Frodsham's Active Travel team's response to Solar farm application.

Summary of response by Frodsham's Active Travel team.

Ref : Frodsham's Active Travel team's response to Solar farm app v17.12.25

Dwg no
3272-01-DCO-02c P03

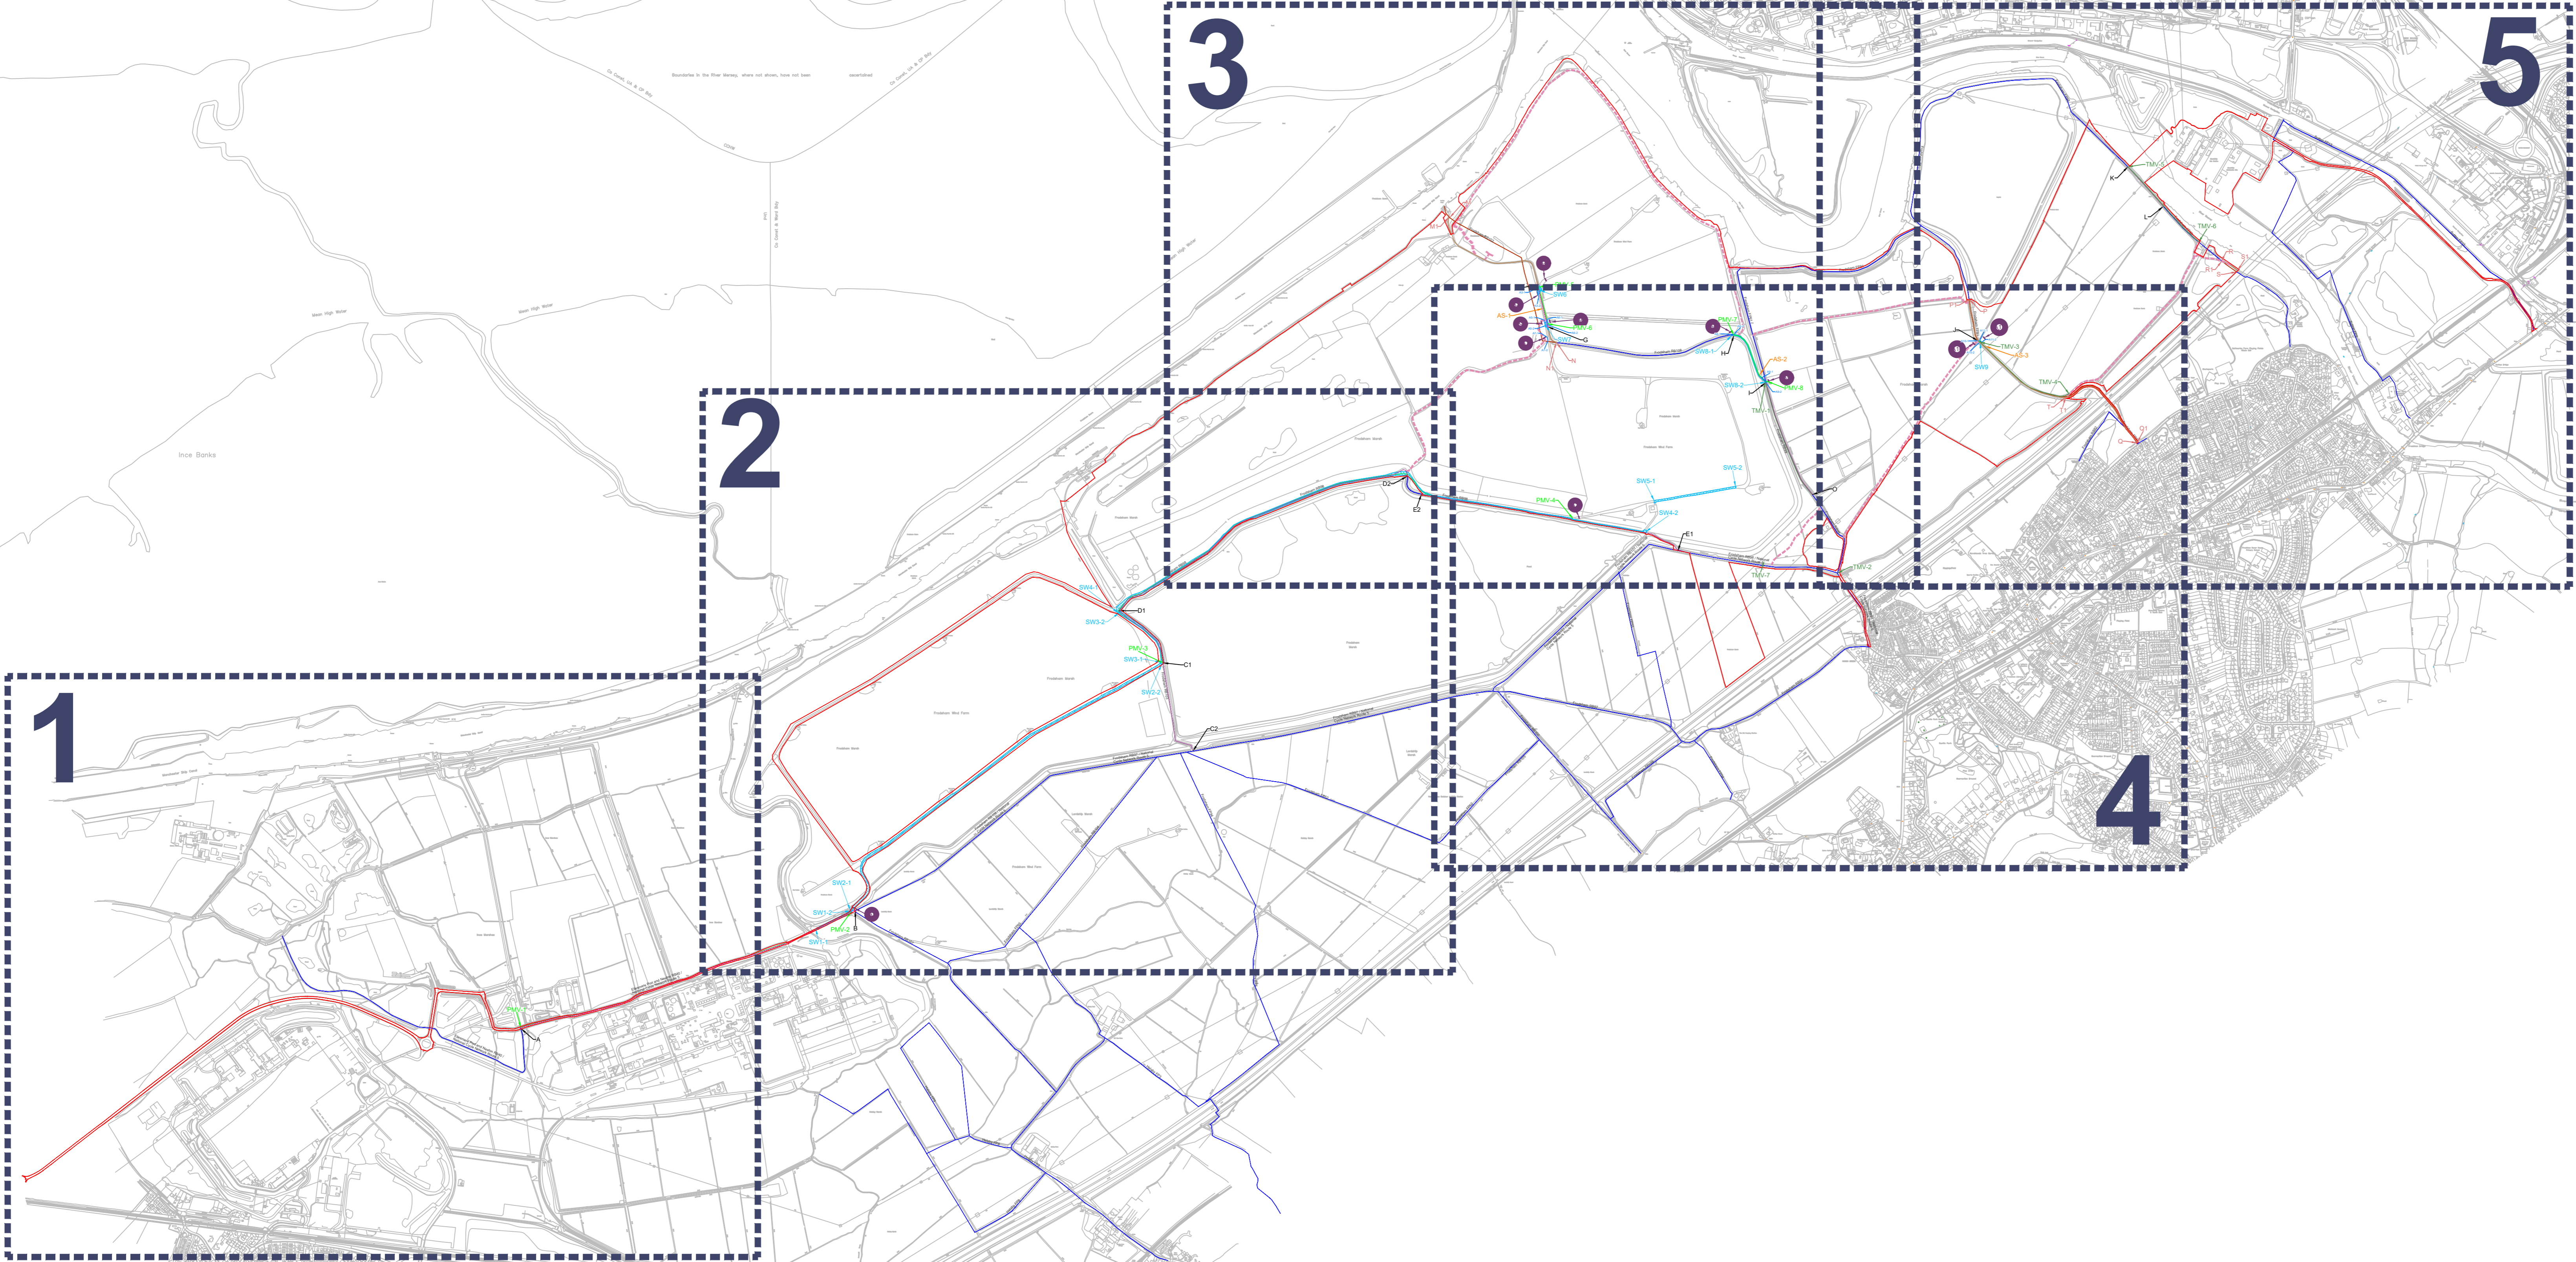
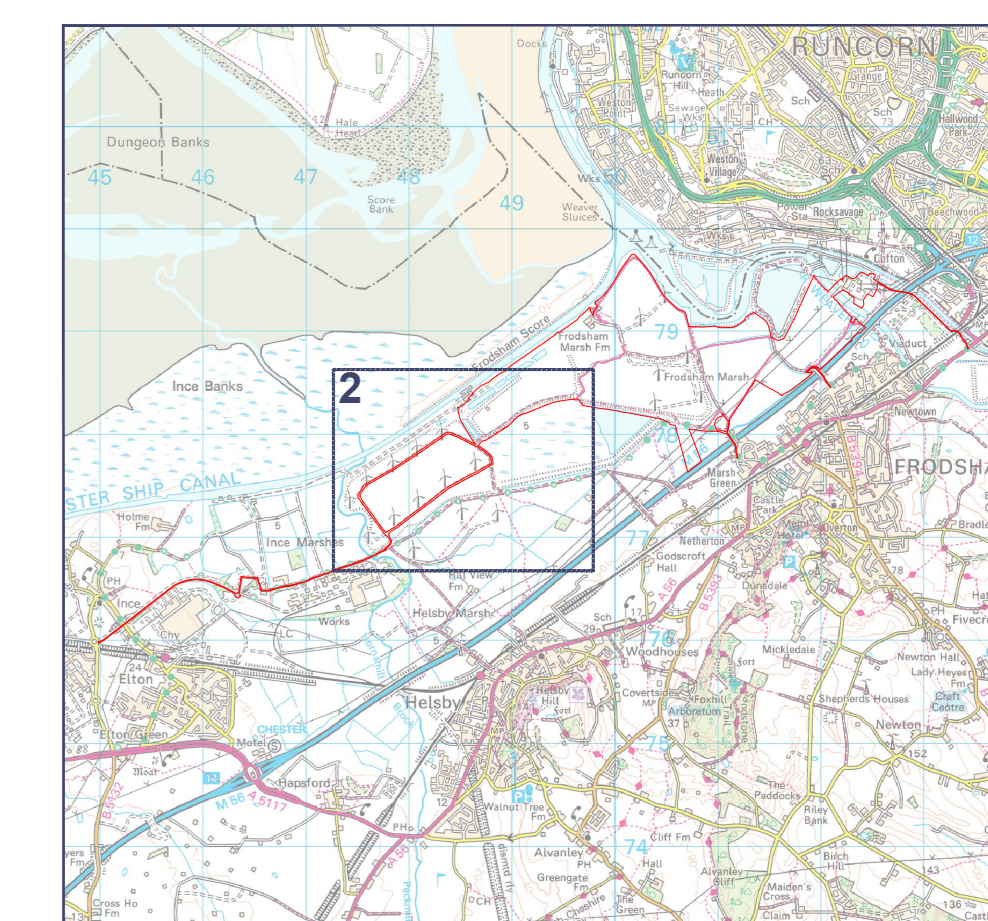
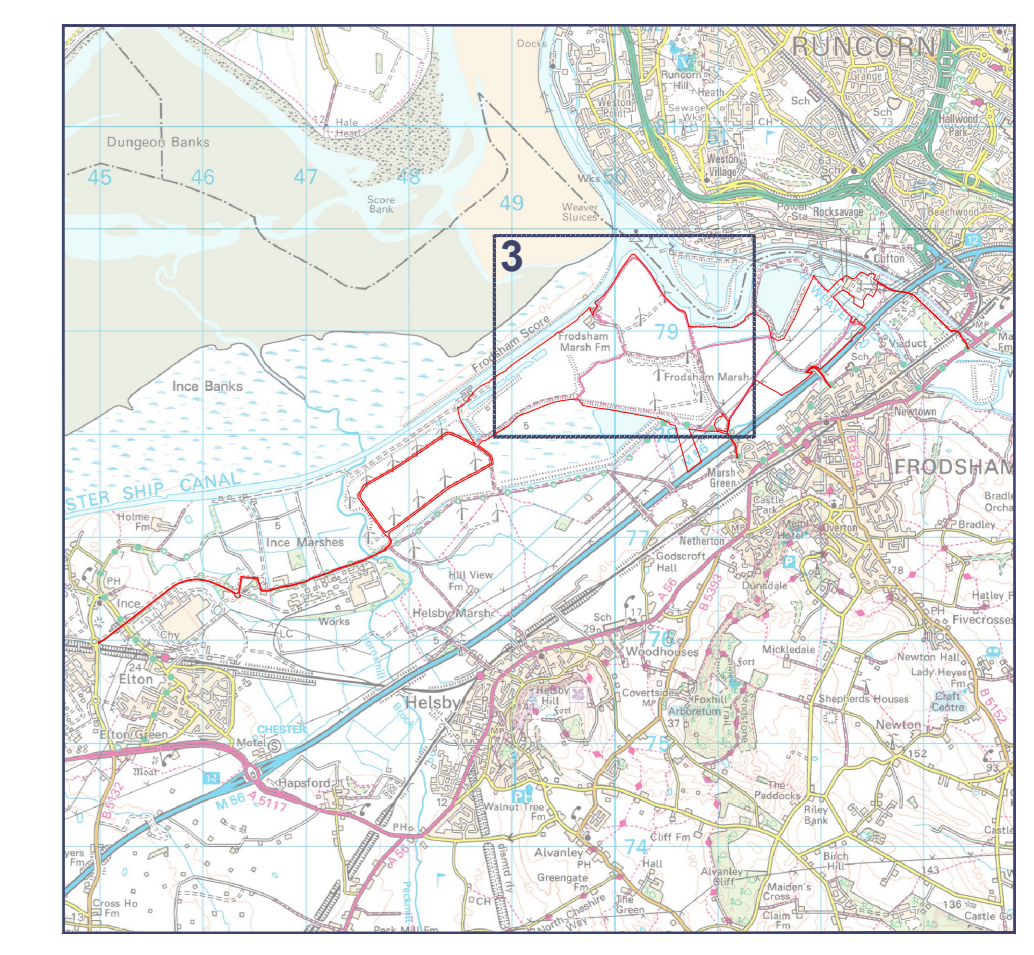
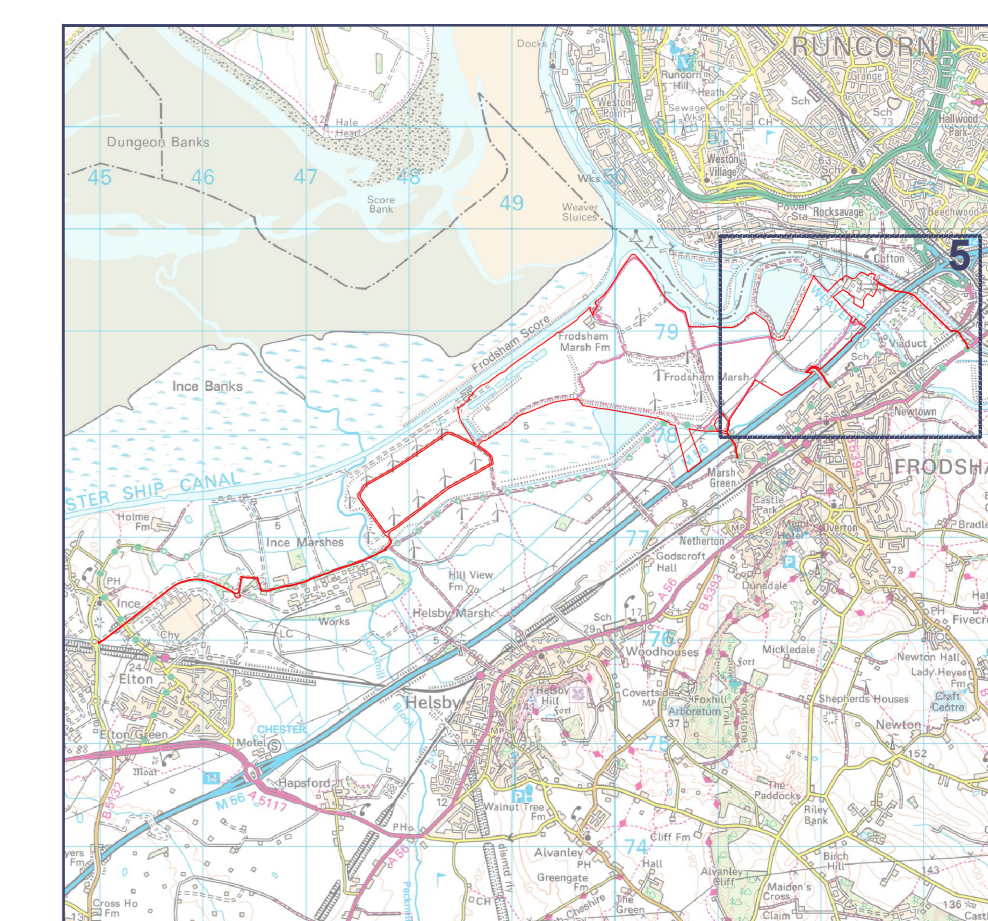
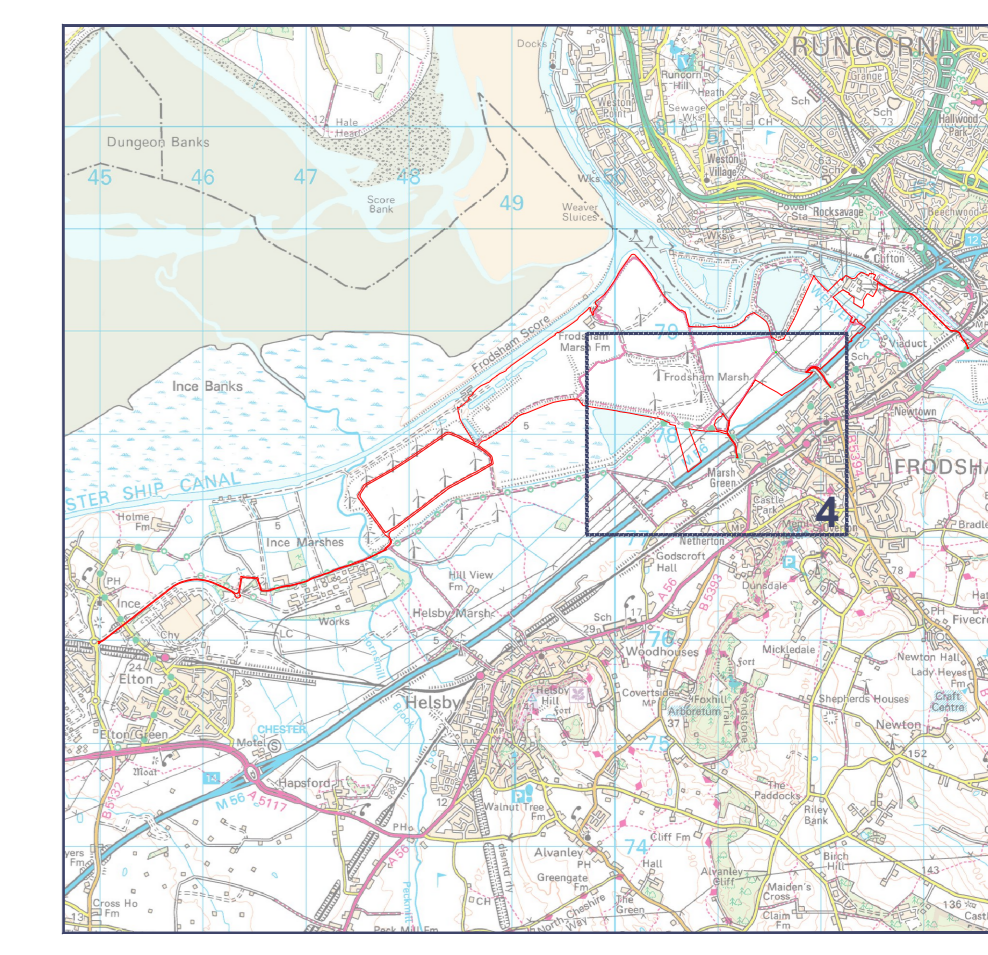
Currently many sections of these Byways which link the site to the town are very badly degraded due to frequent use by heavy agricultural vehicles and are worse in winter with deep flooded potholes. Note : photographic evidence is available. This has a serious adverse impact for not only leisure, commuters and service vehicles but potentially for access by emergency services. We believe that these byways should be improved as part of the scheme and that two national and Cheshire West policies are applicable. i.e.
